CITY OF ALBUQUERQUE

November 25, 2013

**Re: Dental Office, 7500 Holly Ave. NE
Grading and Drainage Plan, Engineer's Stamp Date (C-19/D058)**

GRADING AND DRAINAGE PLAN

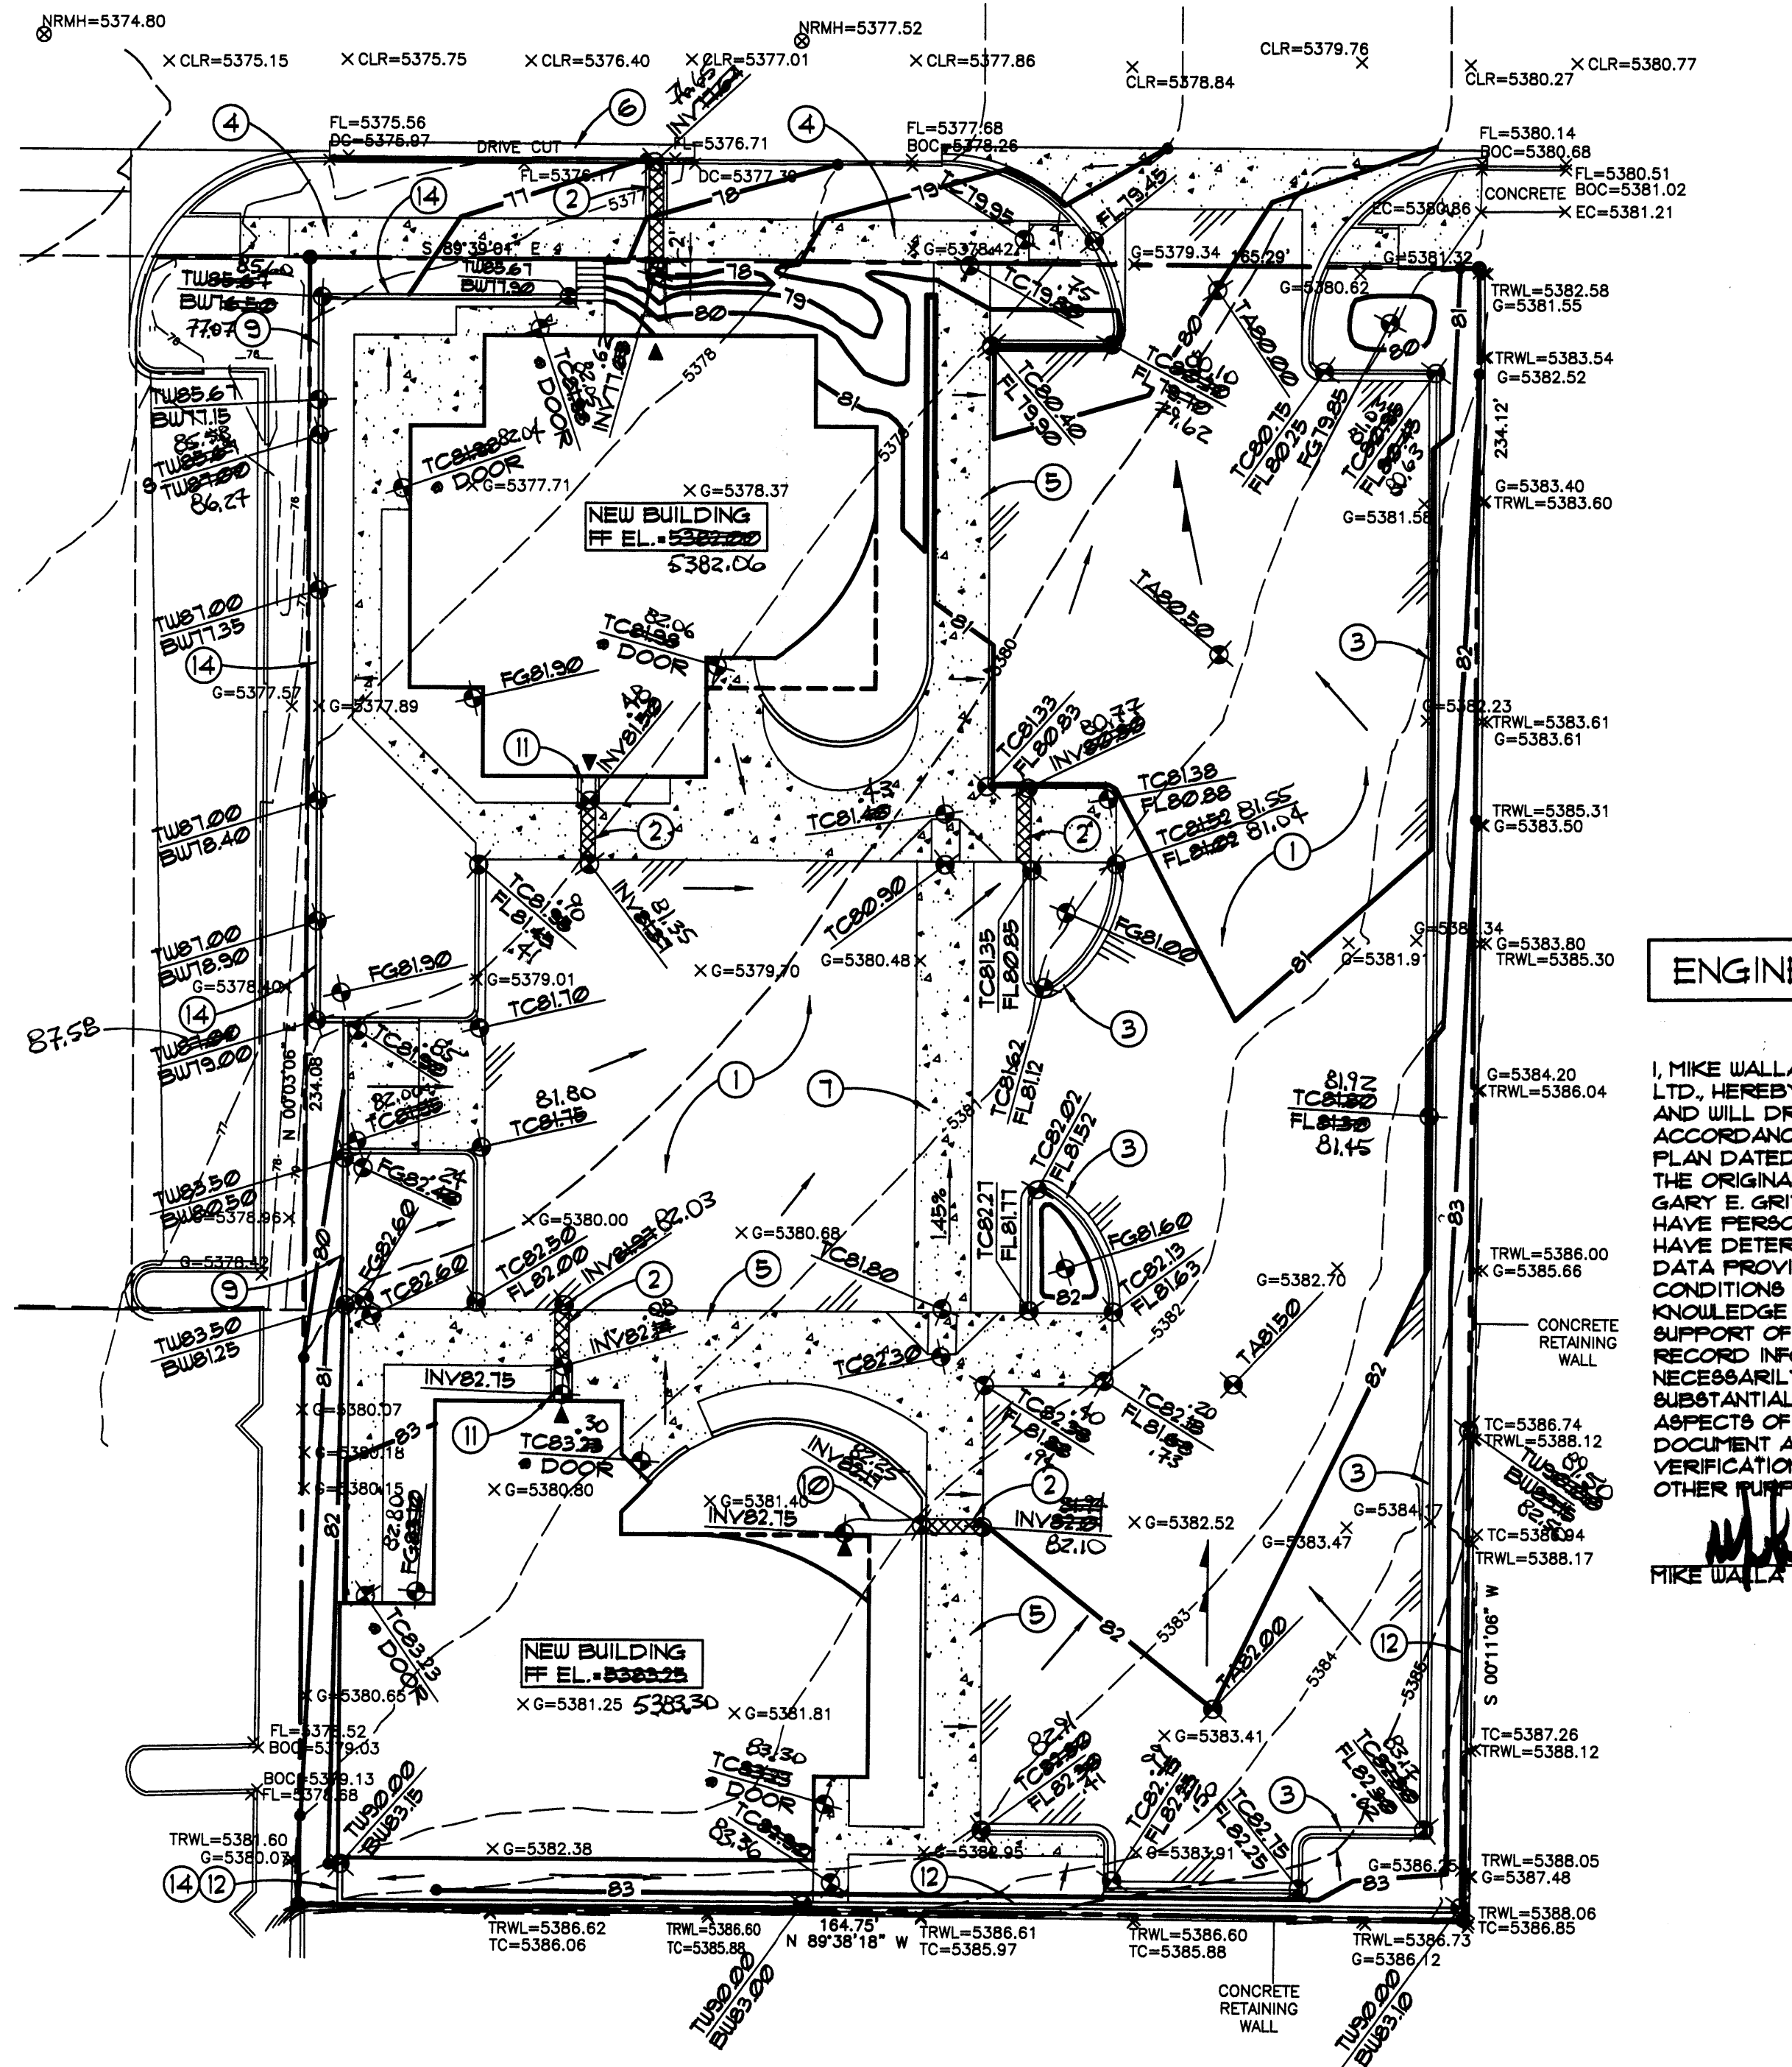
- Provide flowline elevations on both sides of the sidewalk culverts.
- Extend the sidewalk culvert on Holly 2' (to the south) passed the sidewalk. Include a note to "tack weld the bolts at the plate".

- Depress the landscaping areas where possible.
- Is there an extended stem wall required at the northeast corner of the northerly building? The grades north of the building appear to be steeper than 3:1. What kind of the slope treatment is being proposed? Flowline elevation at the sidewalk culvert is +/- 5377.00 and finished contour just north of the sidewalk culvert is 5399.00.

- Show handicap parking spaces and grades to assure it meets ADA requirements.
- Provide spot elevation south of the southerly building to assure positive drainage away from the building either to the east or to the west.

- Is the wall along the westerly boundary a retaining wall? Please provide Top or retaining wall elevations? We recommend that the wall be extended to the south in order to drain the runoff south of the trash enclosure east to the parking lot.

- There is a FG of 82.90 west of the southerly building (by the door) that appears to be low.
- Clearly call out the top of the existing and proposed retaining walls along the boundary line.
